CITY OF ALBUQUERQUE
PLANNING DEPARTMENT
DEVELOPMENT REVIEW BOARD

6. Project # 1002957
03DRB-01784 Major-Vacation of Public Easements

JEFF MORTENSEN & ASSOCIATES INC. agent(s) for ALBUQUERQUE PUBLIC SCHOOLS request(s) the above action(s) for all or a portion of Tract(s) 26A-1, **TAYLOR RANCH**, zoned R-T residential zone, located on TAYLOR RANCH DR NW, between MONTANO RD NW and HOMESTEAD CR NW containing approximately 14 acre(s). [REF: 03DRB-01524 & 01525] (D-11)

VACATION REQUEST (RESUBMITTAL)
TRACT A, LYNDON B. JOHNSON MIDDLE SCHOOL
DRB PROJECT #1002957

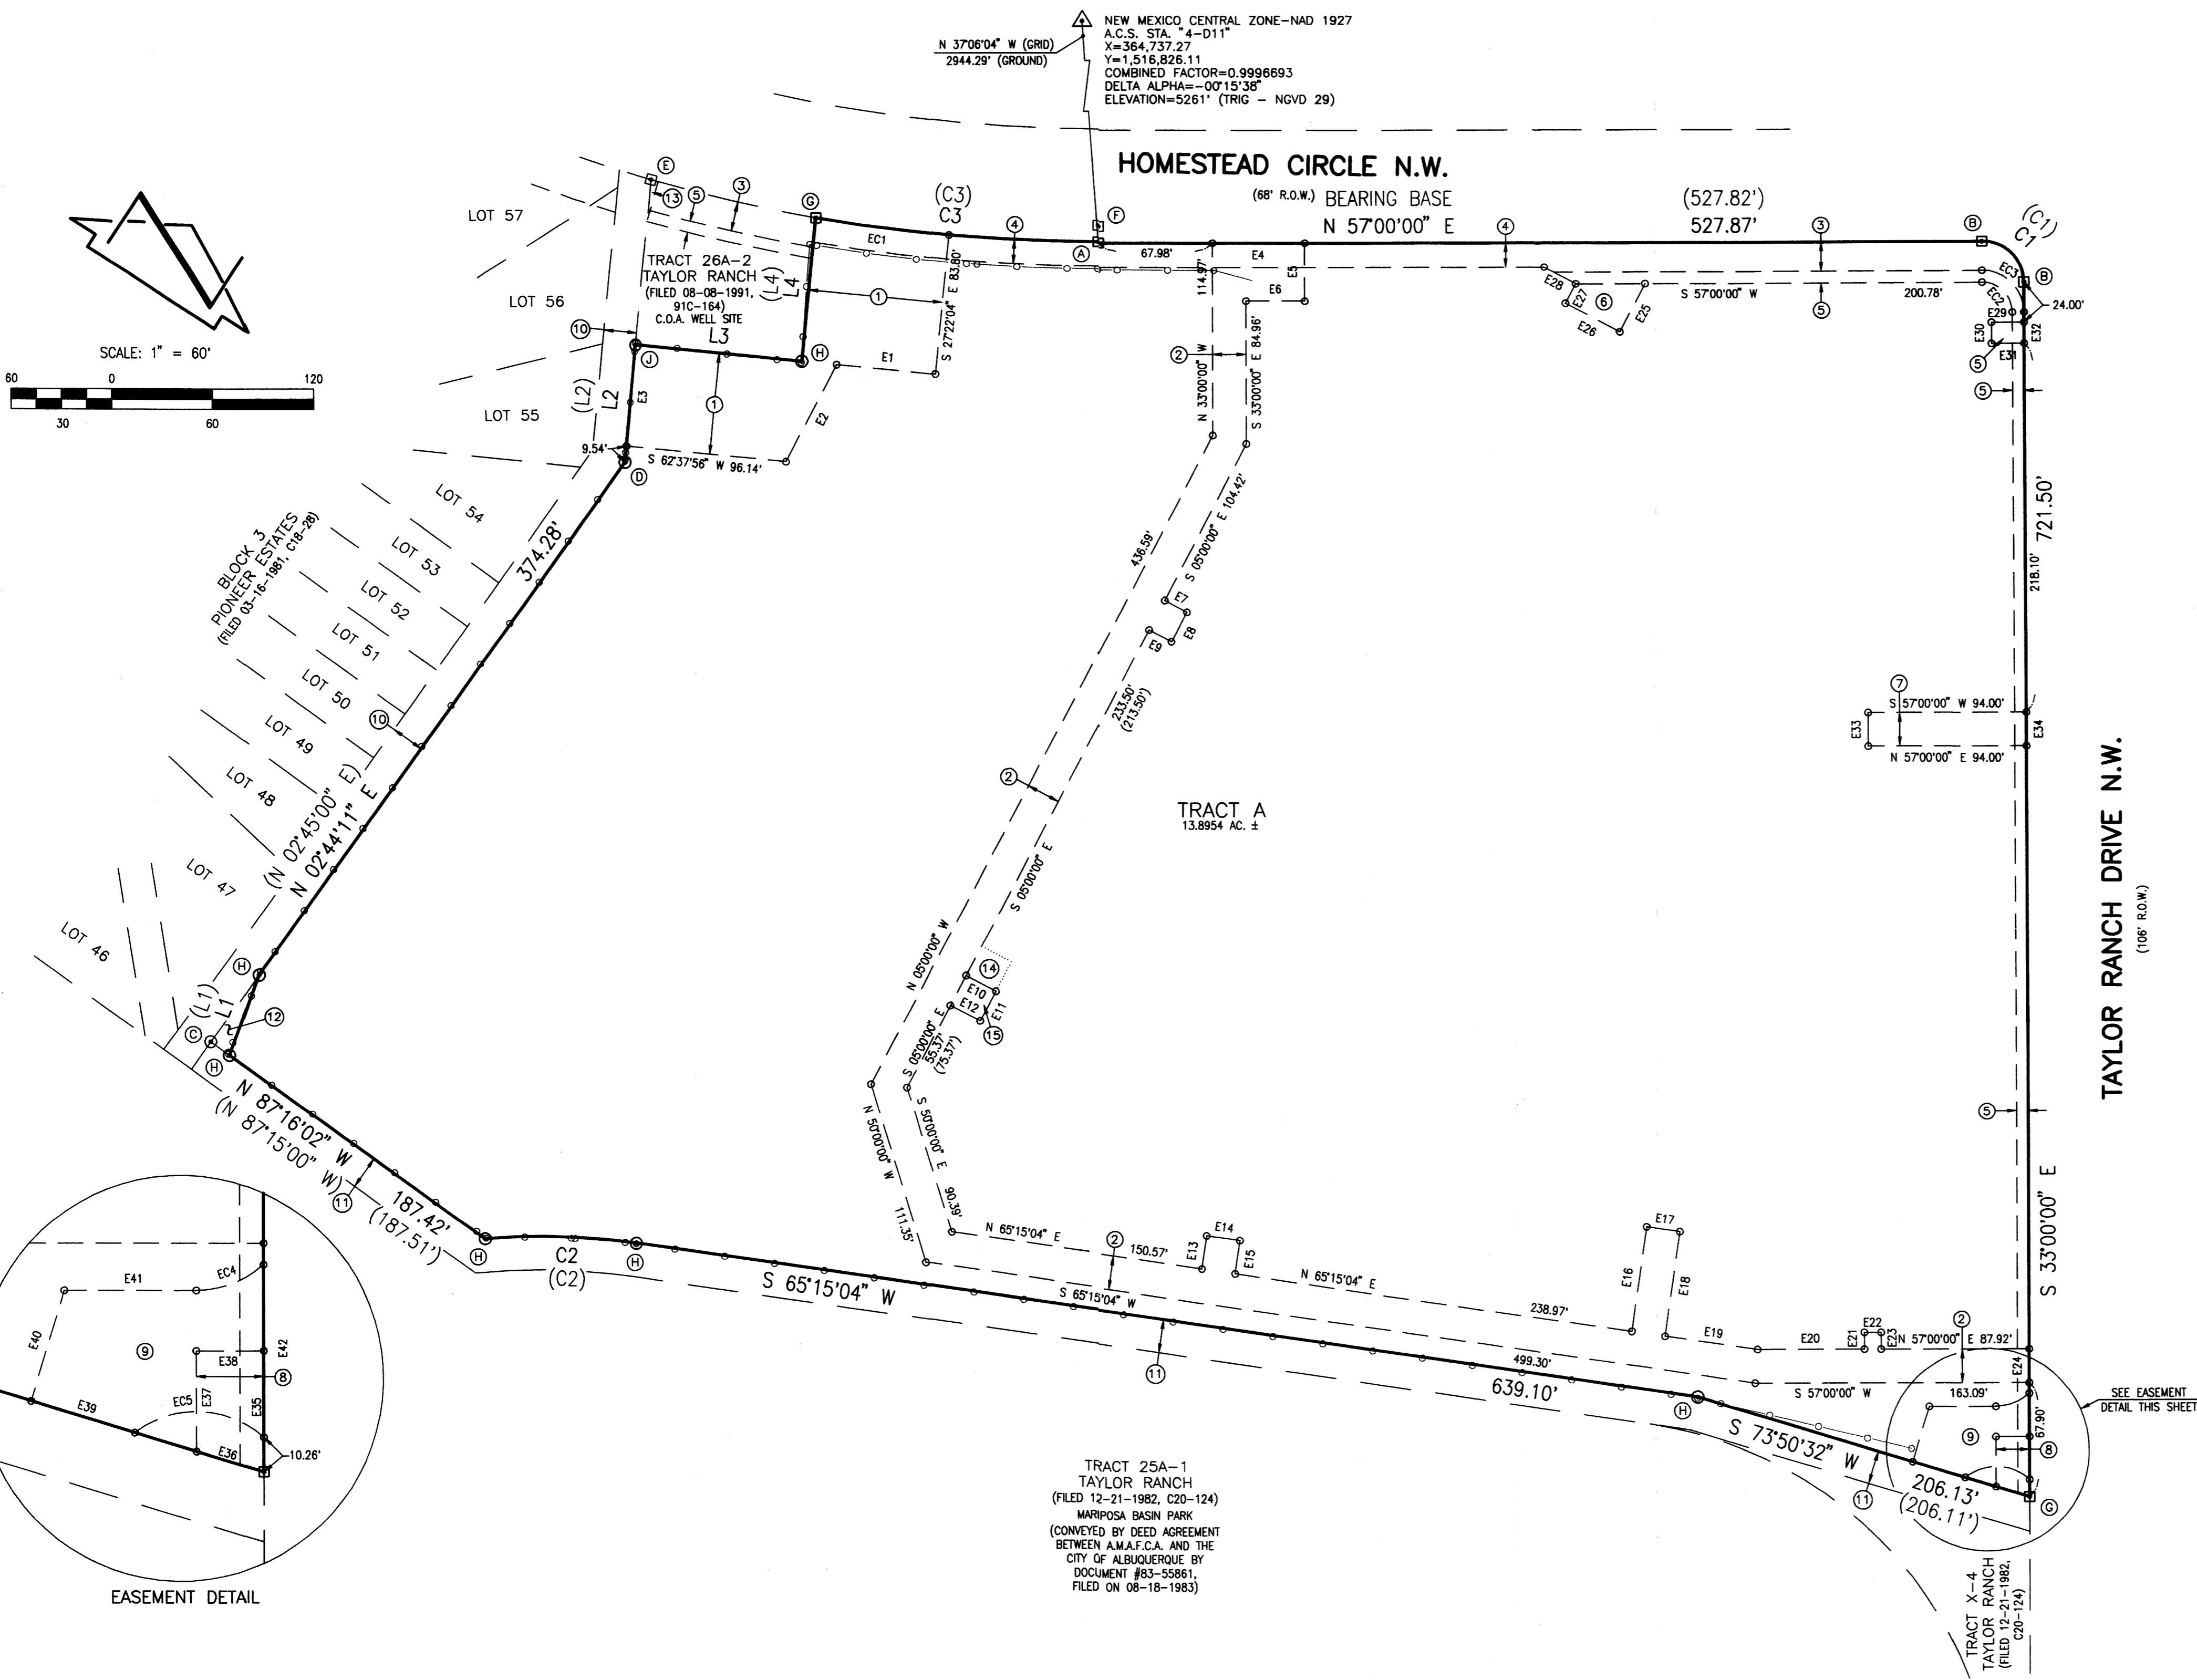
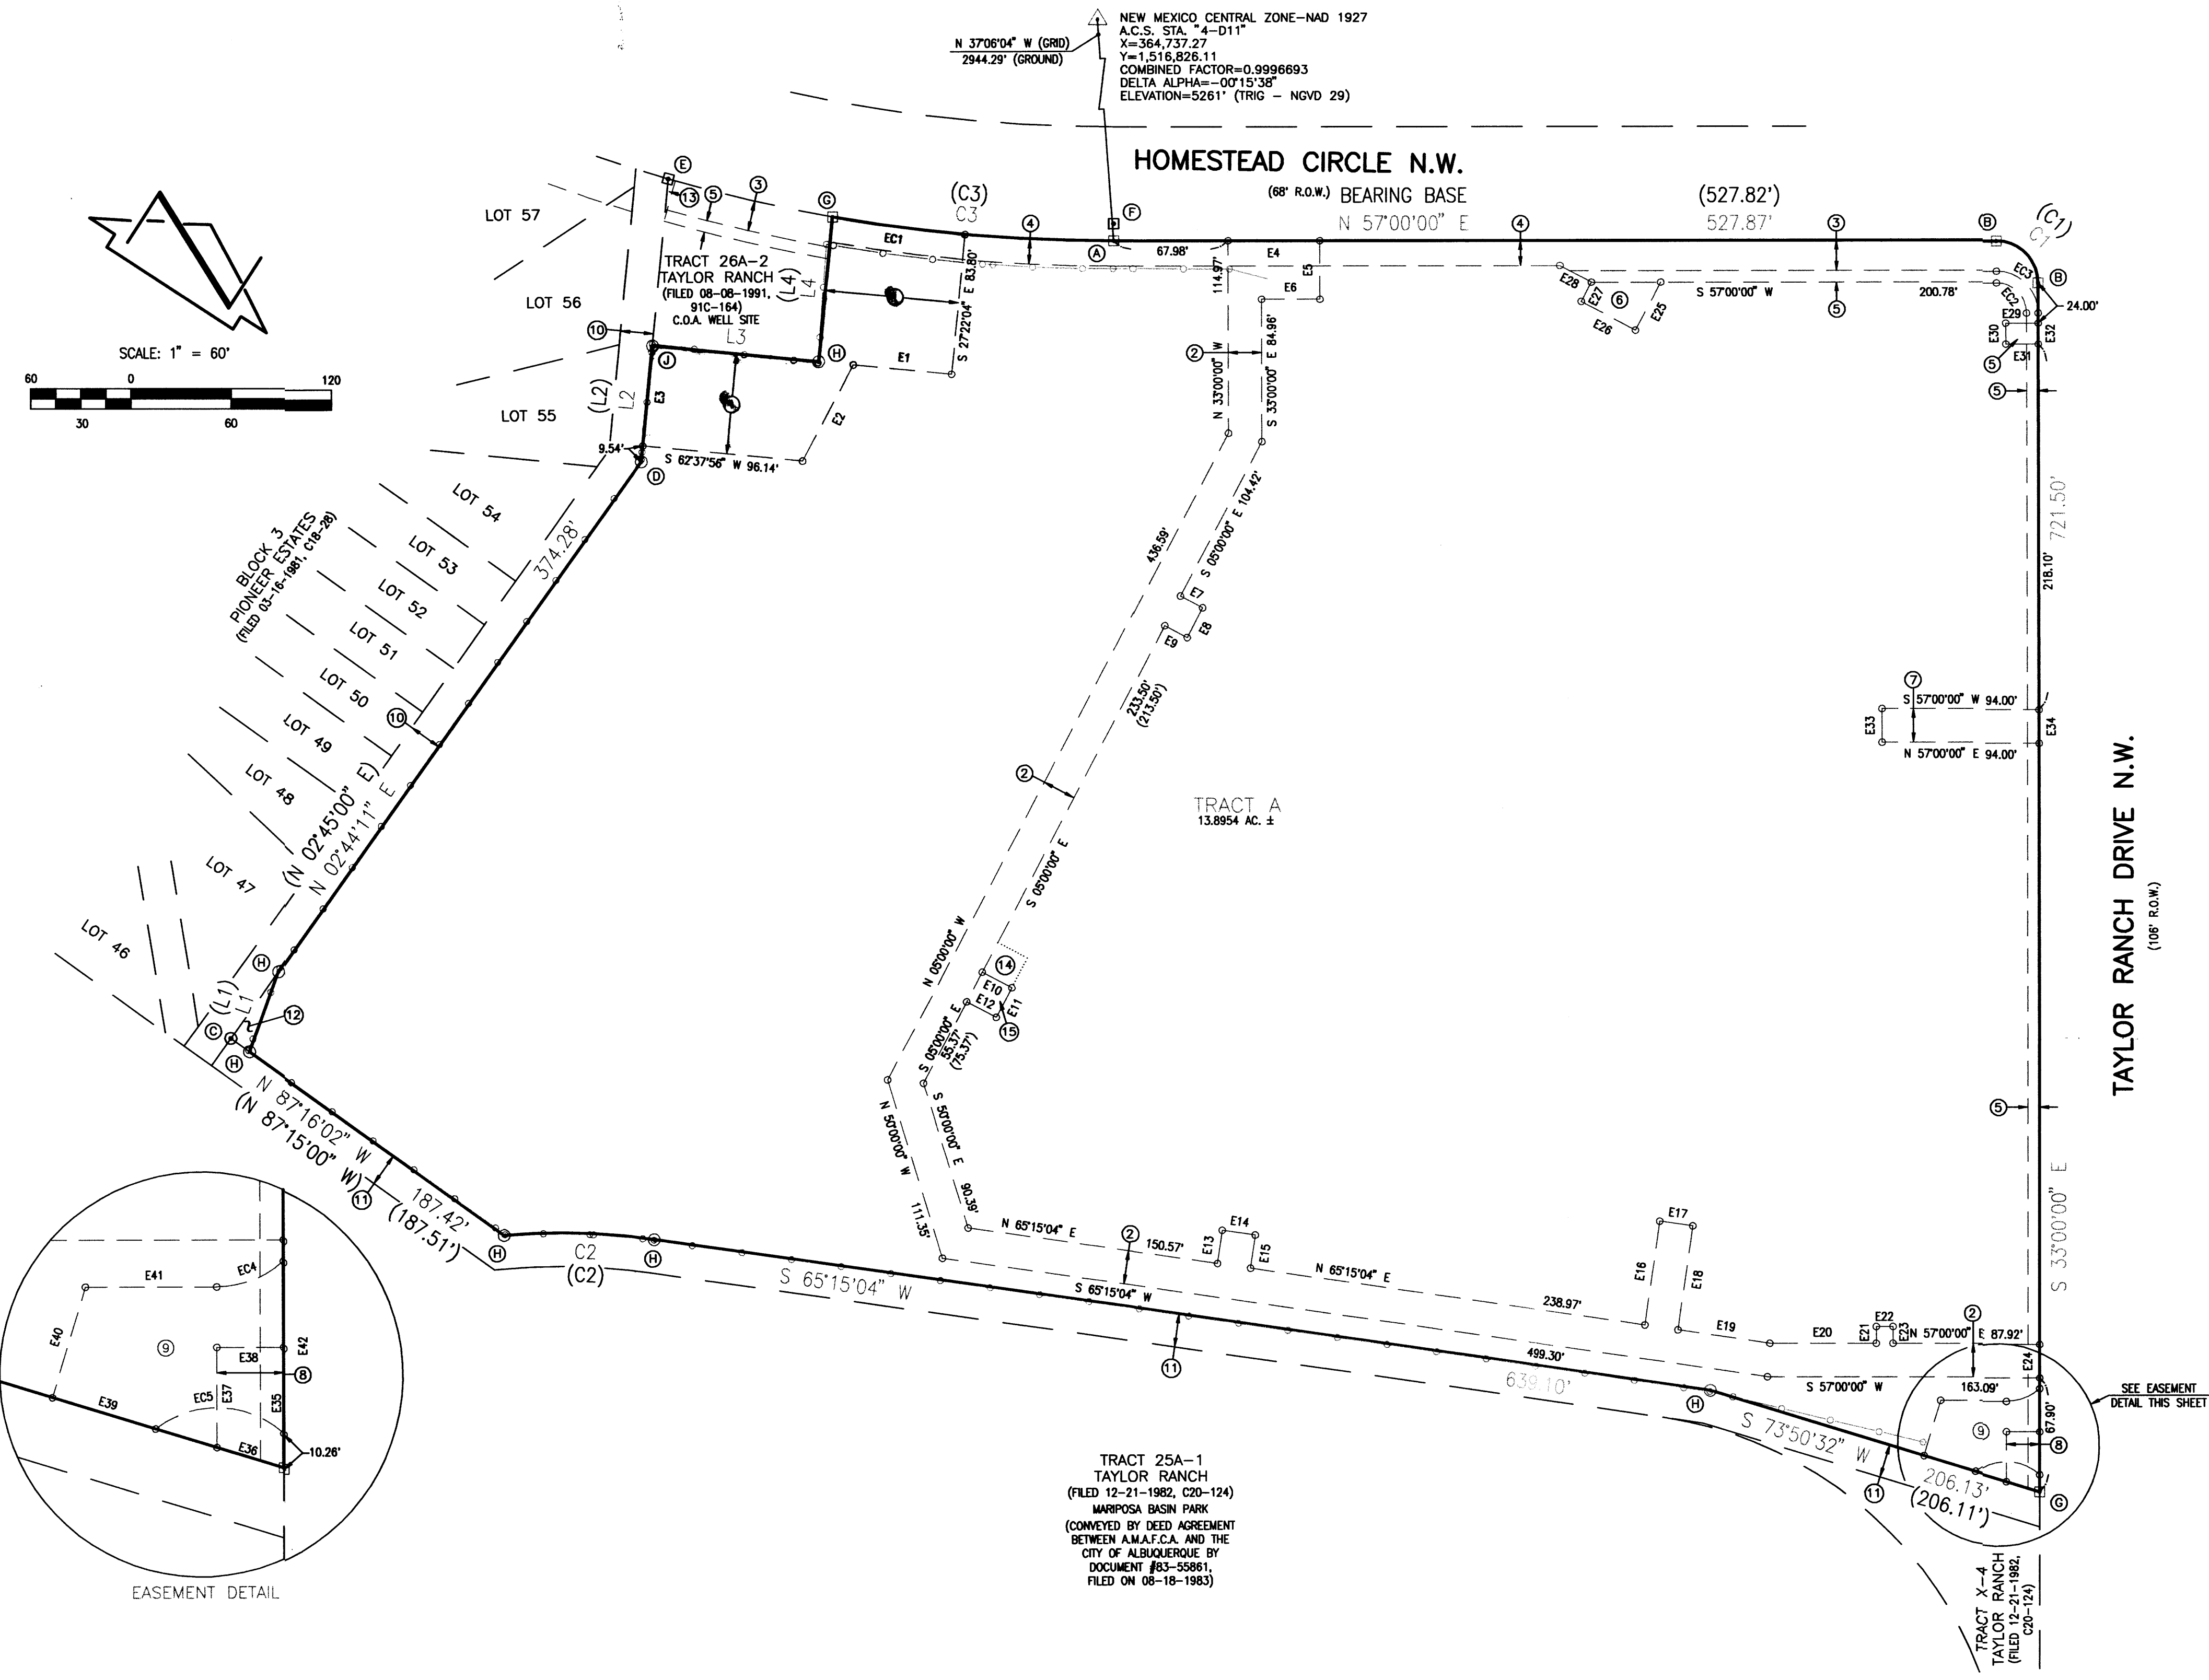
At the November 12, 2003, Development Review Board meeting, the Vacation approved as shown on Exhibit B in the Planning file, subject to these provisions:

1. Prior to final plat approval a replacement temporary construction easement acceptable to the City's Water Utility Division and approved by the City Engineer shall be provided on the final plat.
2. The public welfare is in no way served by retaining the rights-of-way and/or easements, or:
3. There is a net benefit to the public welfare because the development made possible by the vacation is clearly more beneficial to the public welfare than the minor detriment resulting from the vacation.
4. There is no convincing evidence that any substantial property right is being abridged against the will of the owner of the right.
5. Final disposition shall be through the City Real Estate Office.
6. The vacated property shall be shown on a replat approved by the Development Review Board and the approved replat shall be filed for record with the Bernalillo County Clerk's Office within one year.
